SCOPING OPINION:

Proposed South East Strategic Reservoir Option (SESRO)

Case Reference: WA010005

08 October 2024

Figure 9.3 Landscape character: ZTV Visibility and potential viewpoints and photomontage locations

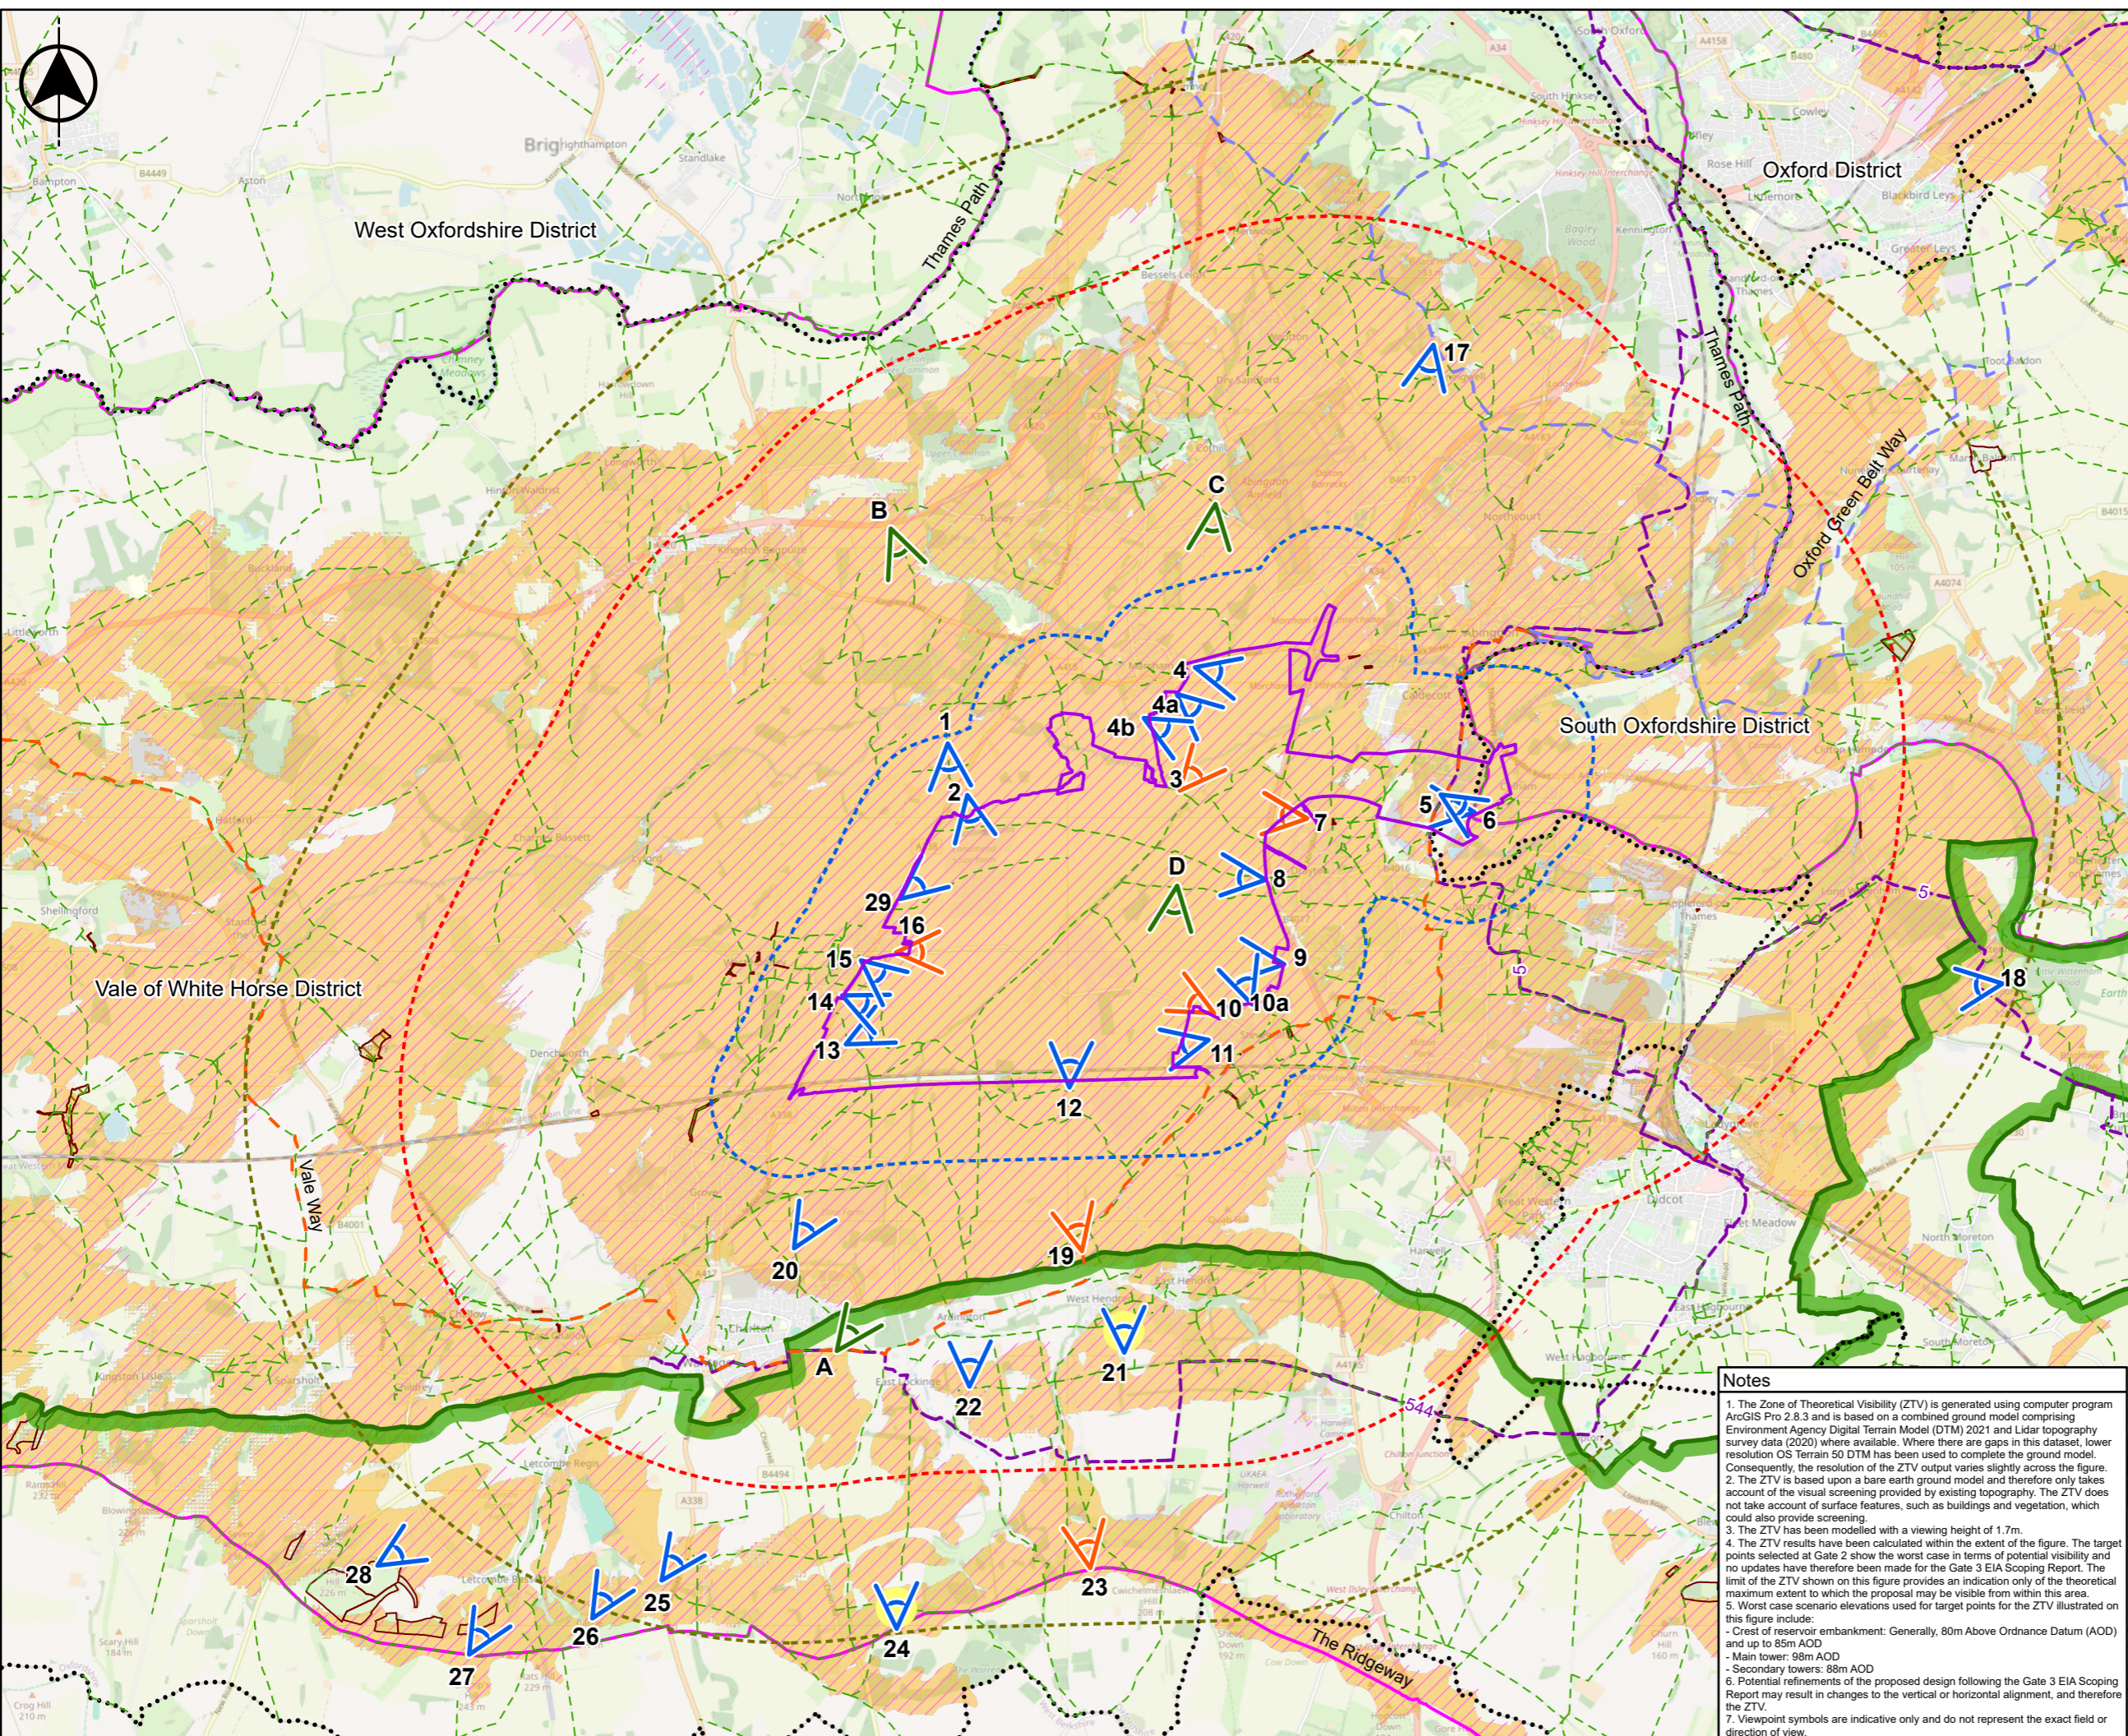
ID	Ref	Description	Inspectorate's comments
354	Paragraph 10.4.1 and Figure 9.3	Study area	The Scoping Report states that historic environment data has been acquired for an area which includes a 2km buffer beyond the scoping boundary. However, the Zone of Theoretical Visibility (ZTV) mapping provided at Figure 9.3 identifies potential visibility beyond these extents. The ES should establish the study area with reference to the extent of the likely impacts and informed by fieldwork and the ZTV. The Applicant should agree this study area with relevant consultation bodies where possible. Any receptors outside of this study area but within the ZTV of the Proposed Development should also be included within the assessment.
355	Paragraph 10.8.10	Assessment methodology – cumulative effects	The Scoping Report states that intra-development effects may arise from the historic environment visual impacts and groundwater impacts. The assessment should cross reference with relevant groundwater impact modelling and assessment to ensure that assets impacted by the changes to ground conditions will be protected throughout the operational period.

Title
FIGURE 11.1
HIGHWAYS STUDY AREA

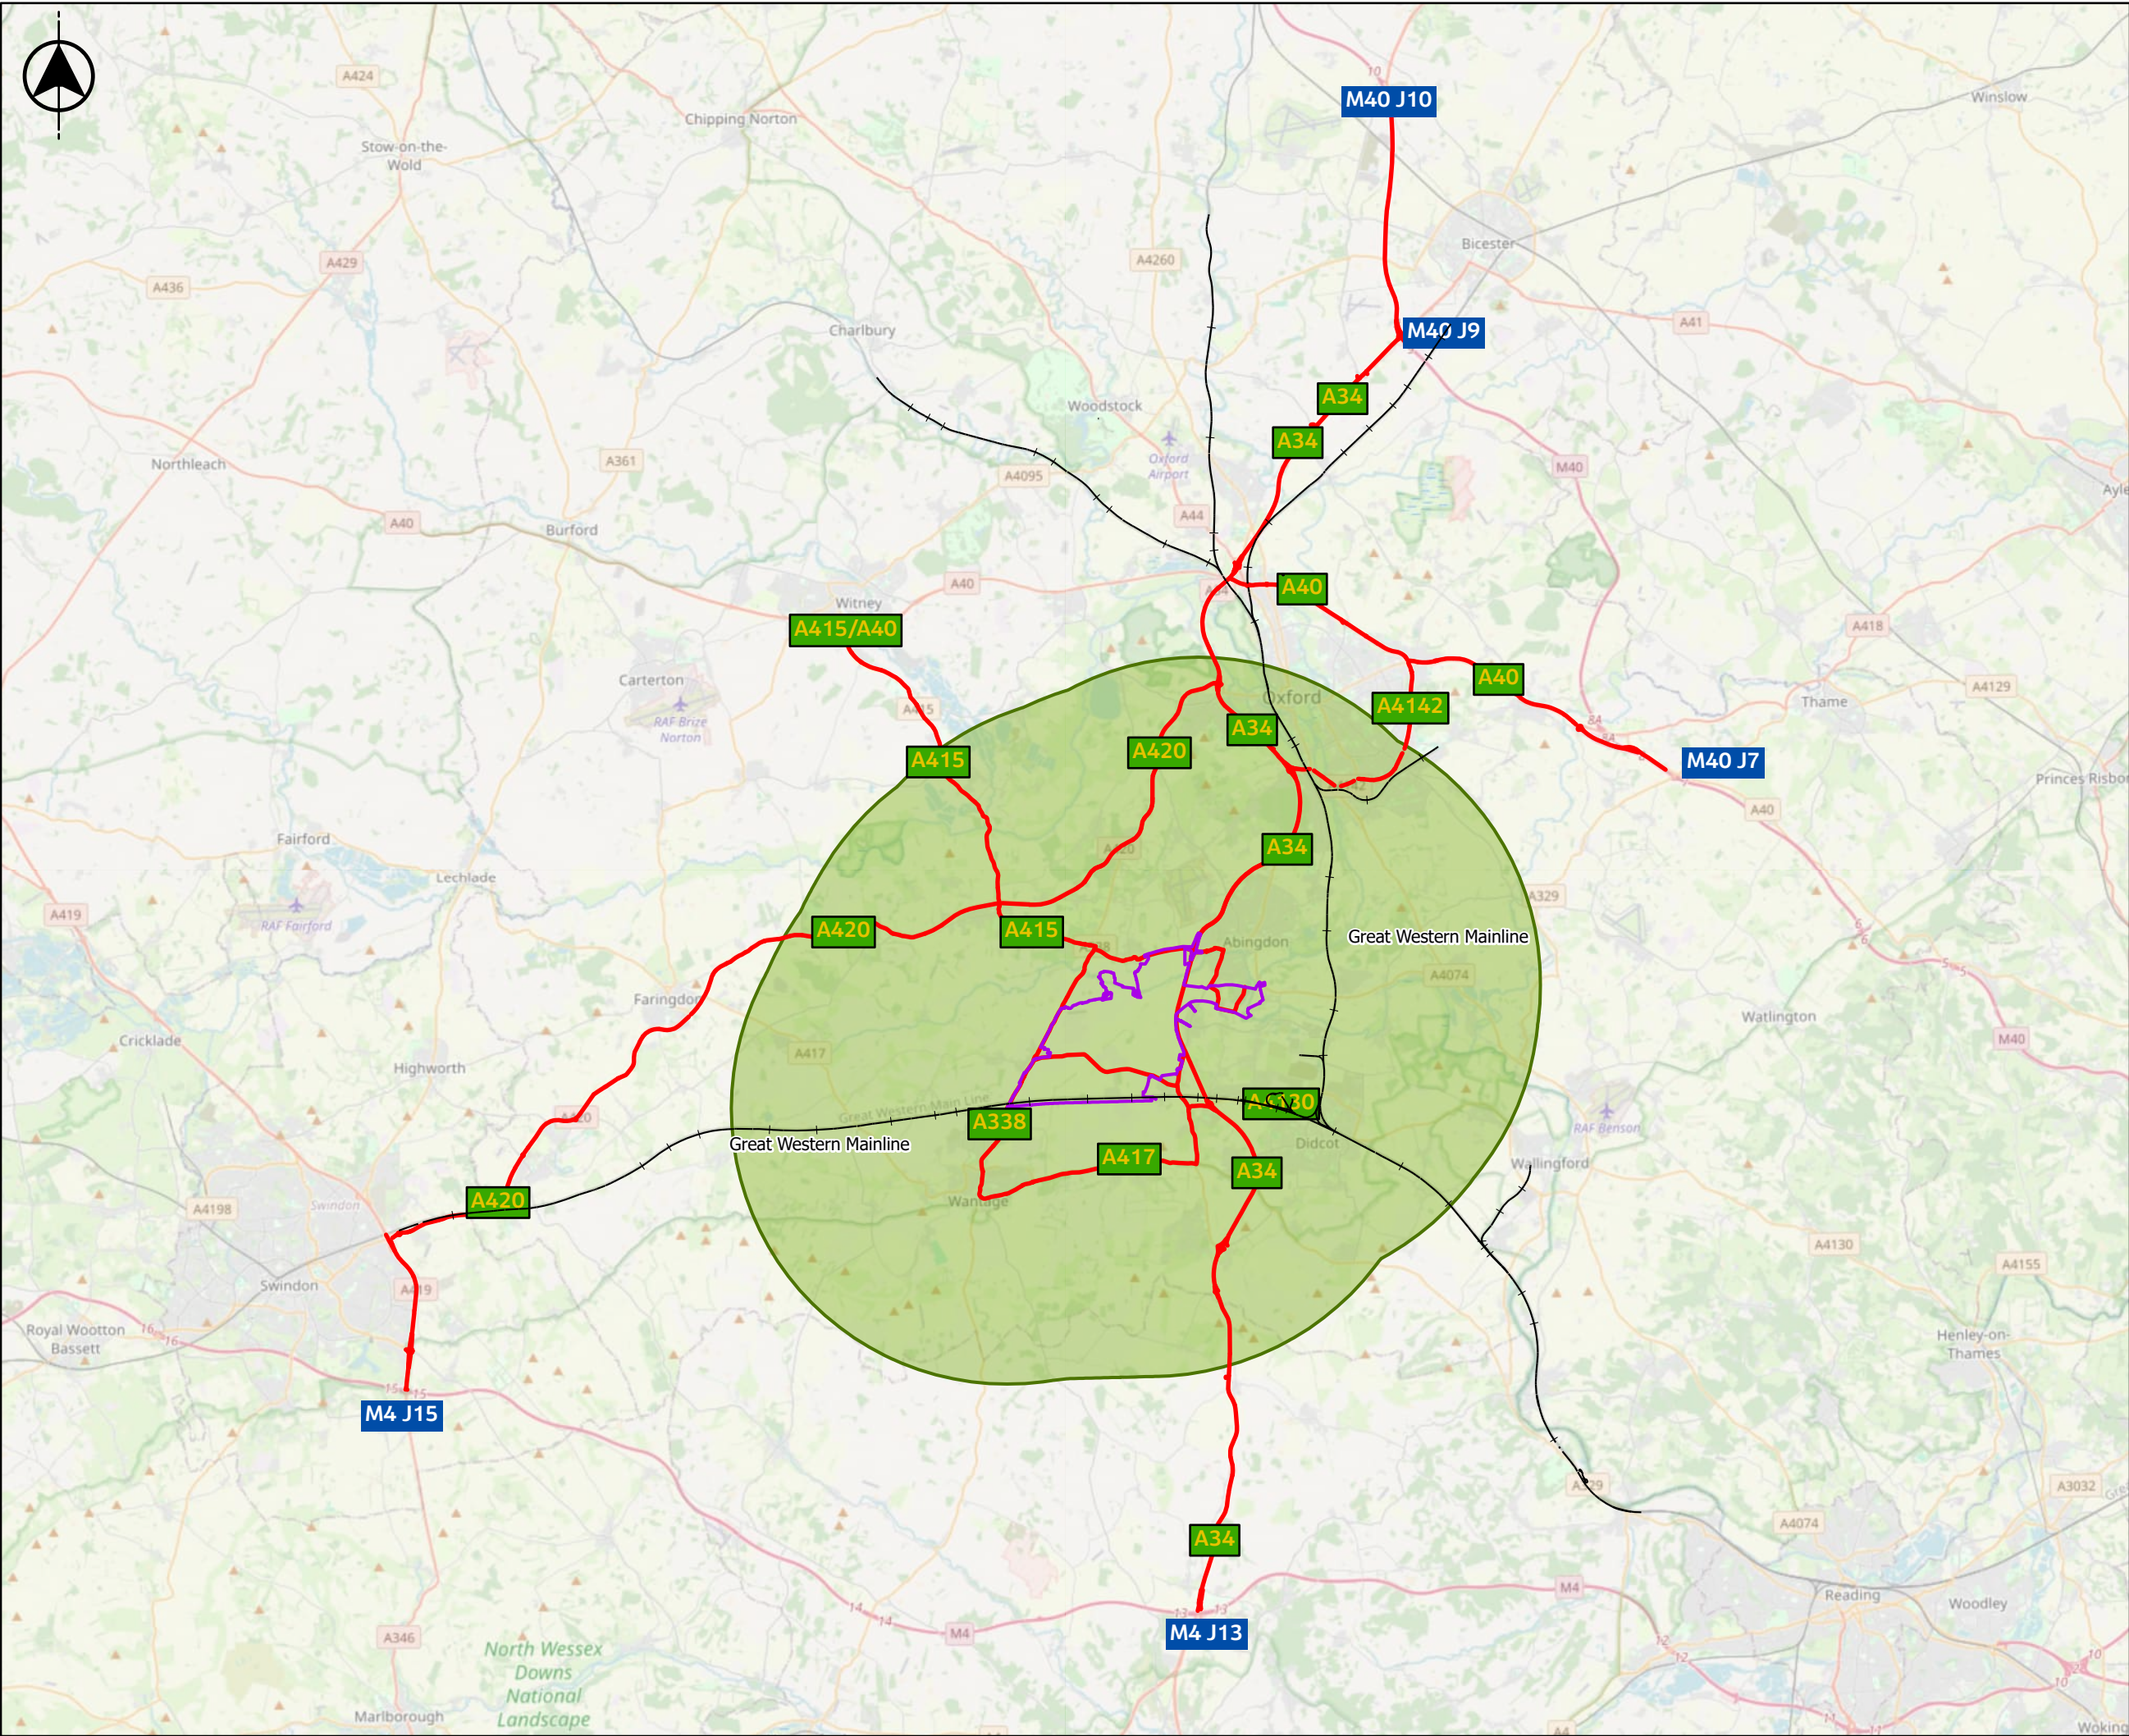
ID	Ref	Description	Inspectorate's comments
362	Paragraph 11.4.2 and Figure 11.1	Study area	Paragraph 11.4.2 of the Scoping Report states that the study area shown in Figure 11.1 has been defined based on professional judgement and would develop as the design evolves. The ES should confirm the final study area and key roads included in the assessment and justify how this has been selected, with reference to relevant industry guidance, the extent of the likely impacts and locations of sensitive receptors and agreement with relevant consultees. A plan illustrating the extent of the study area, and the expected route(s) of construction and operation traffic, should be included in the ES.
363	Paragraph 11.5.32	River Thames navigation	Paragraph 11.5.32 of the Scoping Report states that the River Thames is a nationally significant waterway which is navigable in the vicinity of the proposed intake/outfall infrastructure. There is potential for navigational, and disruption impacts to users of the waterways from the construction of intake/outfall infrastructure. The receptors listed in paragraphs 11.6.2 and 11.6.4 do not include consideration of users of waterways or impacts on navigation infrastructure such as weirs. The ES should assess any likely significant effects on watercourse navigation and navigation infrastructure including any river closures, changes in water levels or narrowing to facilitate construction etc.
